**RE: The Skye Vista - Traffic Conformance Letter**

Matrix Design Group (Matrix) is pleased to present this letter to invest Skye Vista project along Settlers Ranch Road, north of Hodgen Road in El Paso County. This development was previously studied in the 16850 Stepler Road - Traffic Study. According to this study a total of 14 single-family dwelling units were generated. The site plan shows a total of 13 units of single-family homes for this development. We confirm that the total site trips for this development less than what was shown in the memorandum. Table 1 below shows the trip generation comparison between the current and the latest site plan.

ENDLESS SKYE &amp; SETTLERS RANCH INTERSECTION PLAN

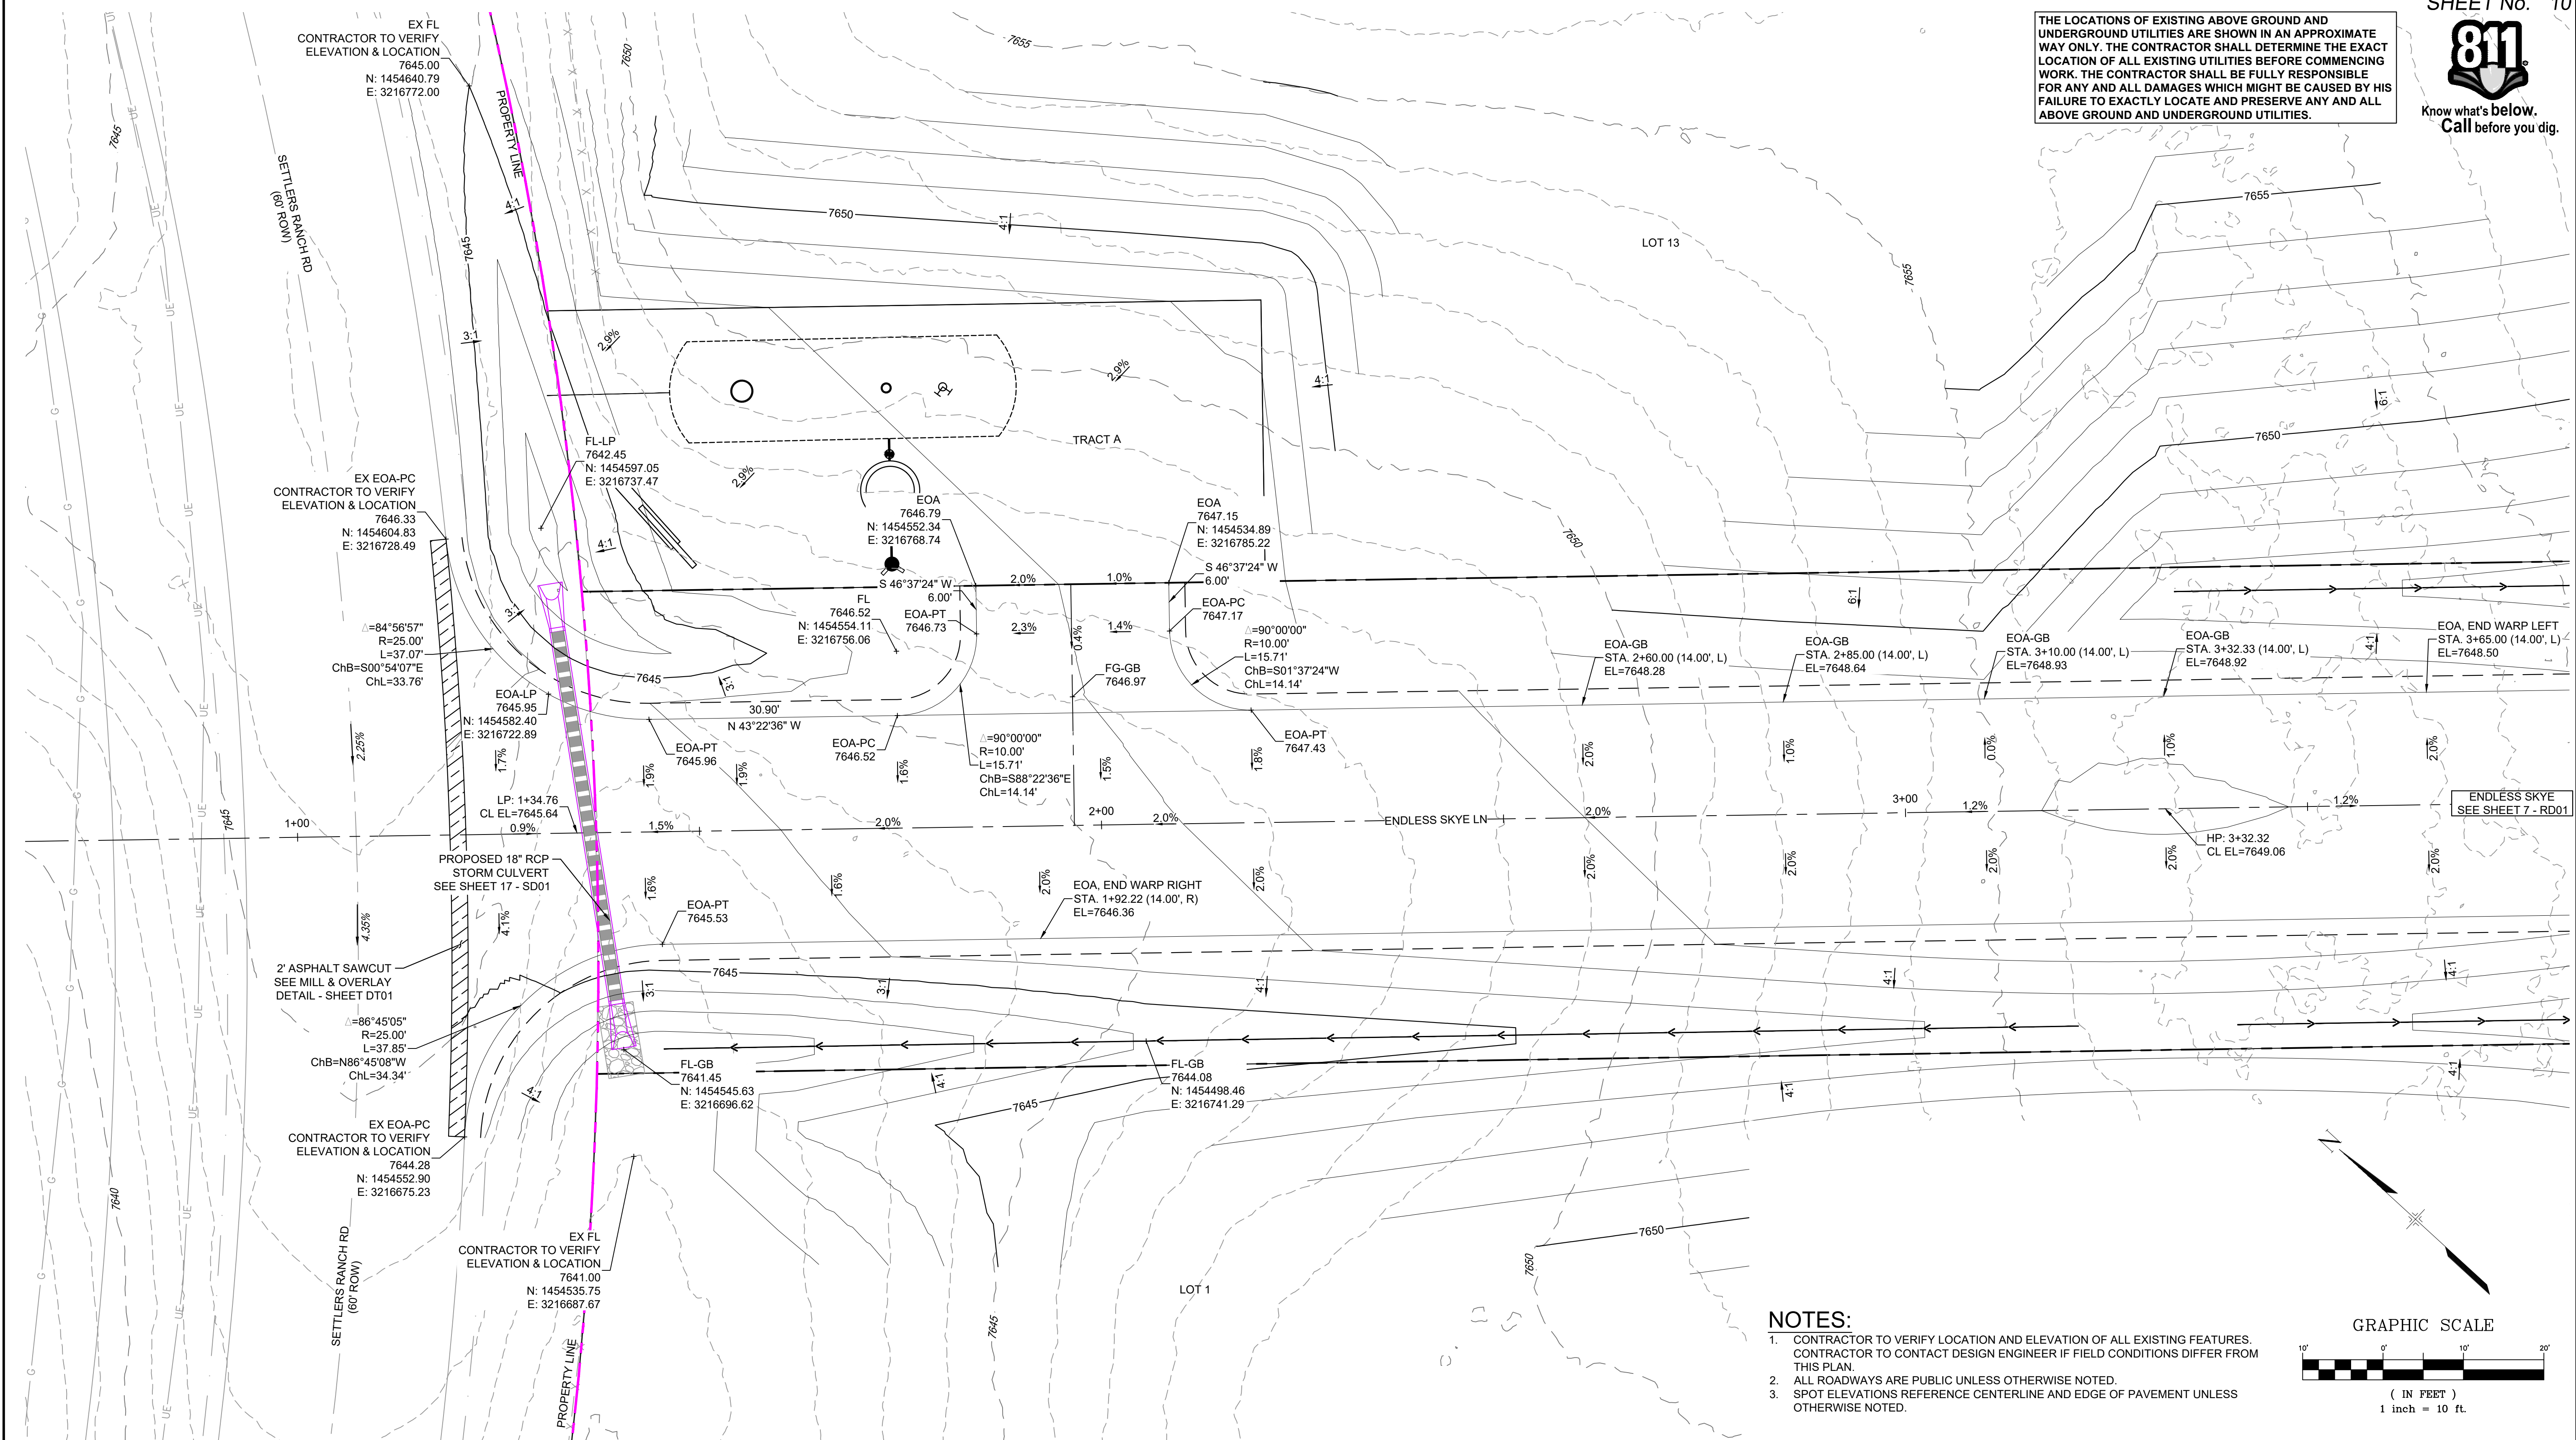
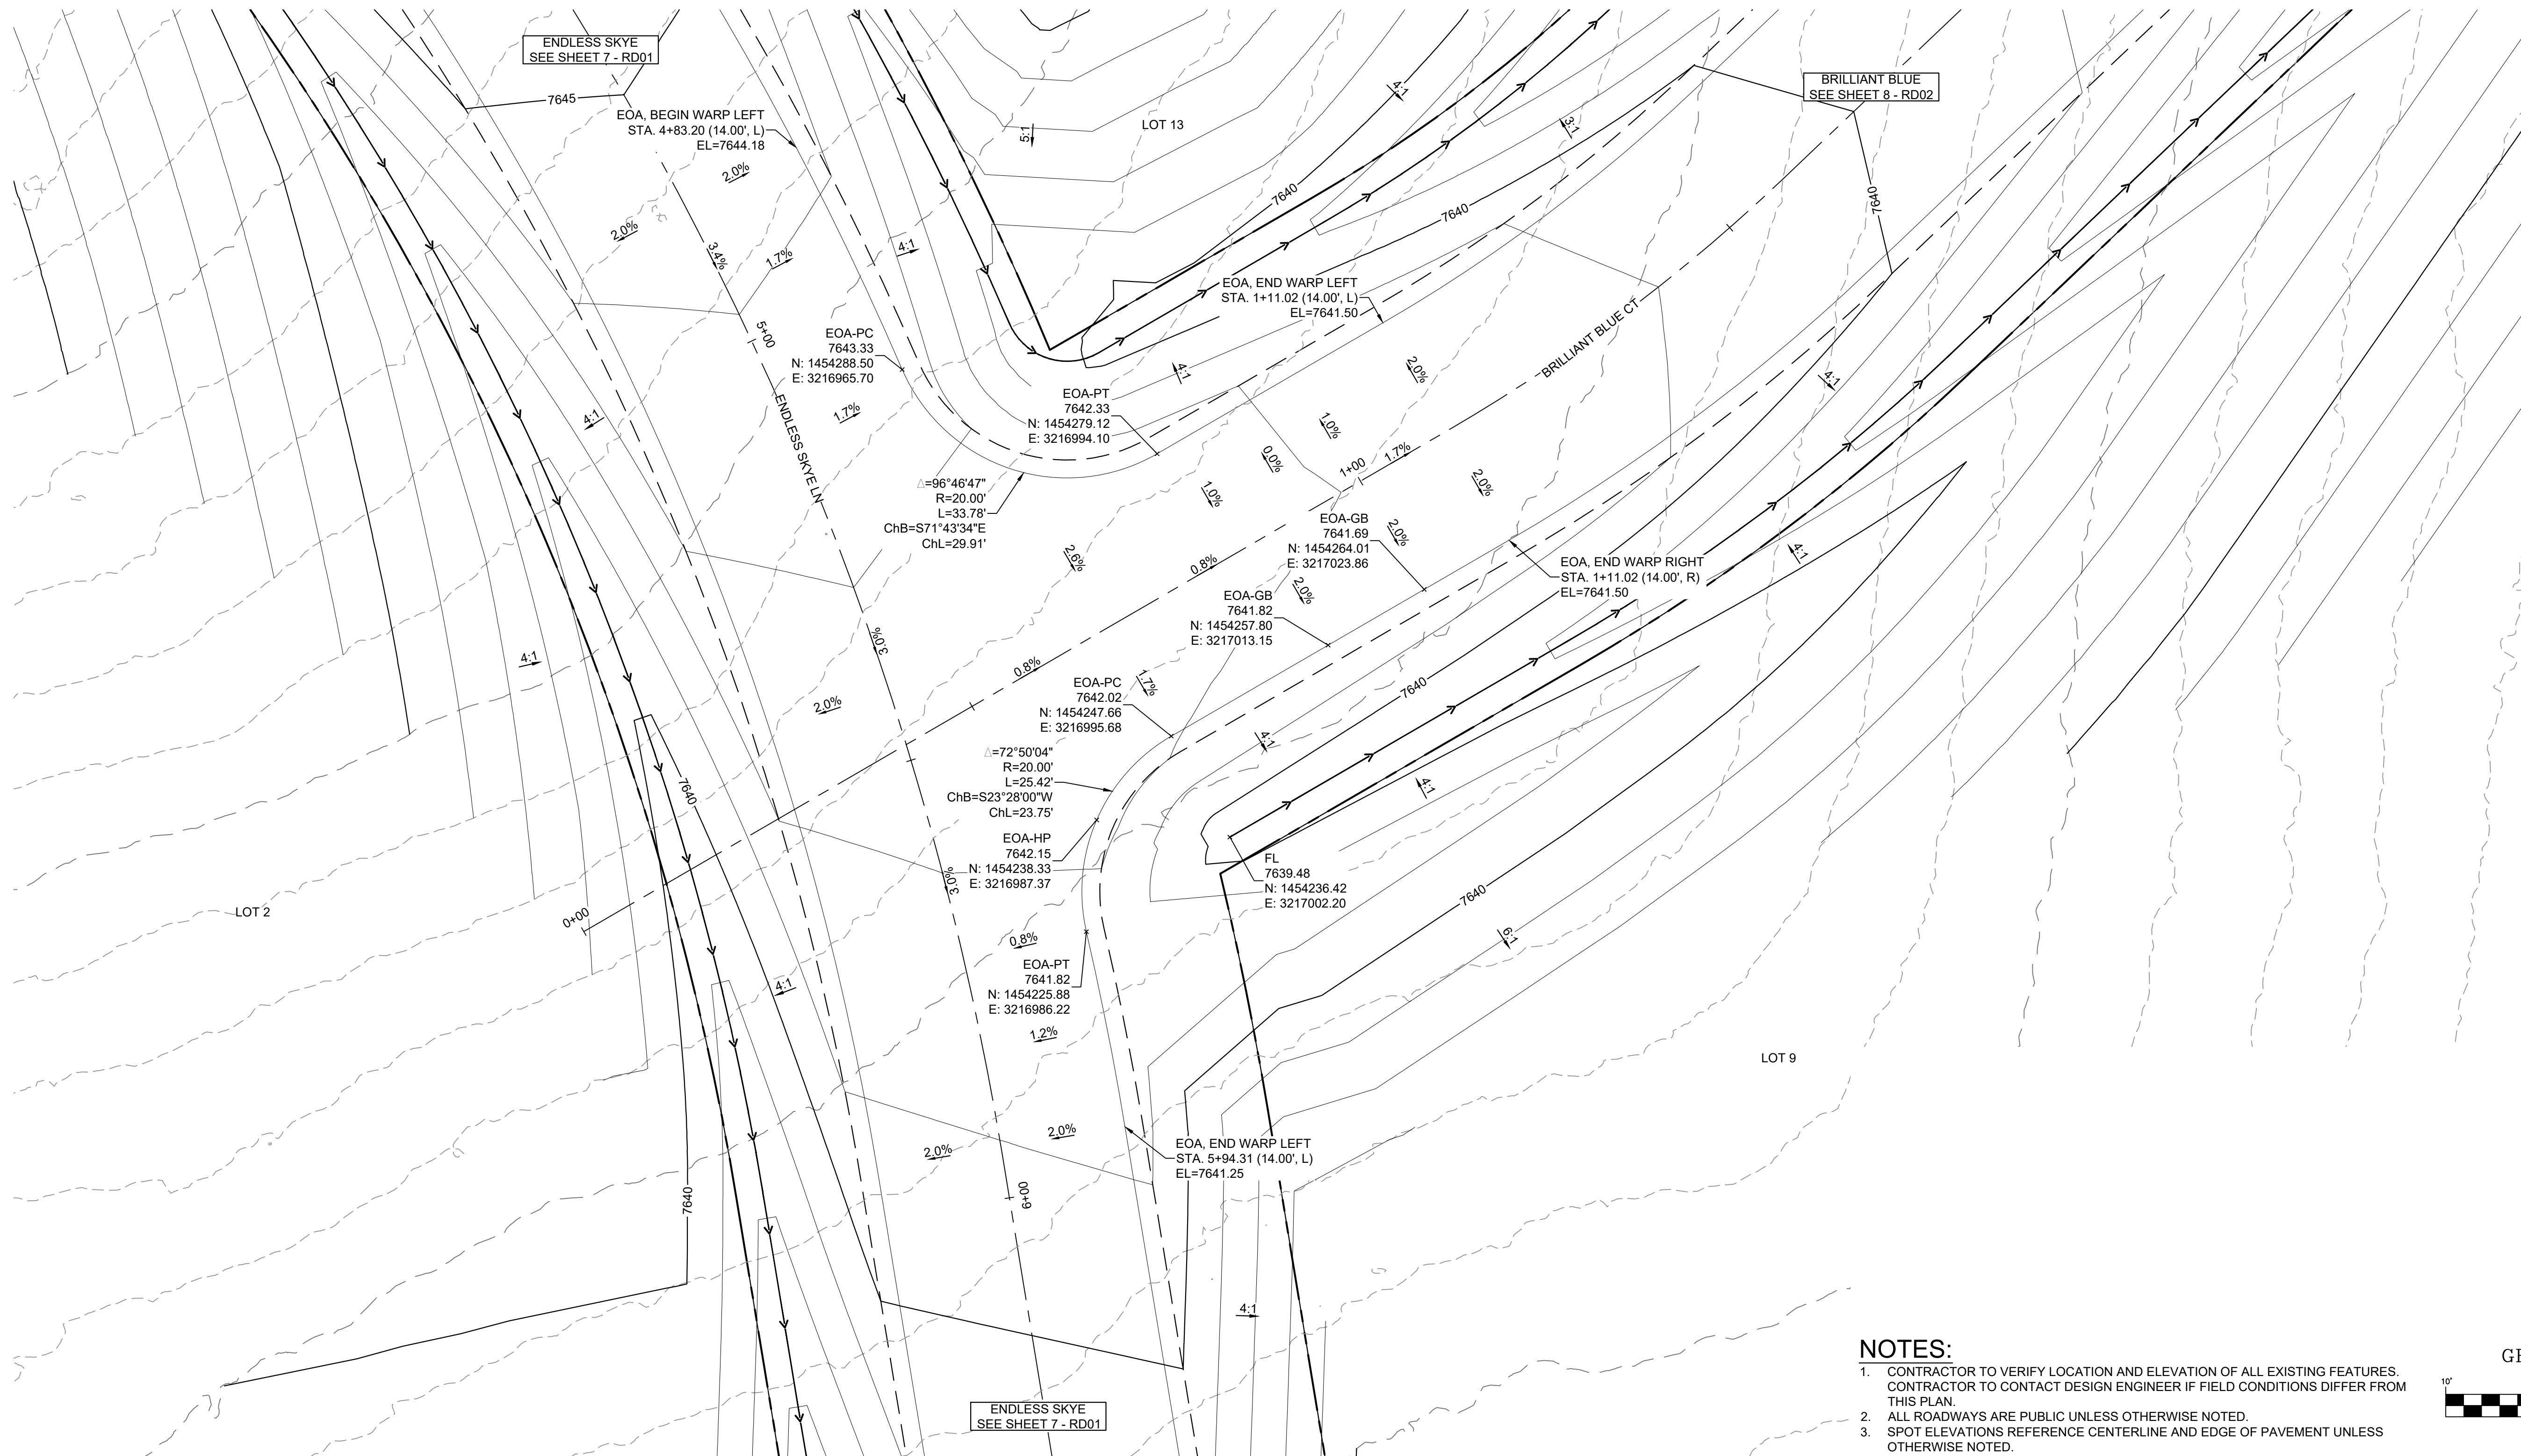
Complete/confirm the line of sight distance for the new intersection Endless Sky with Settlers Ranch Rd.
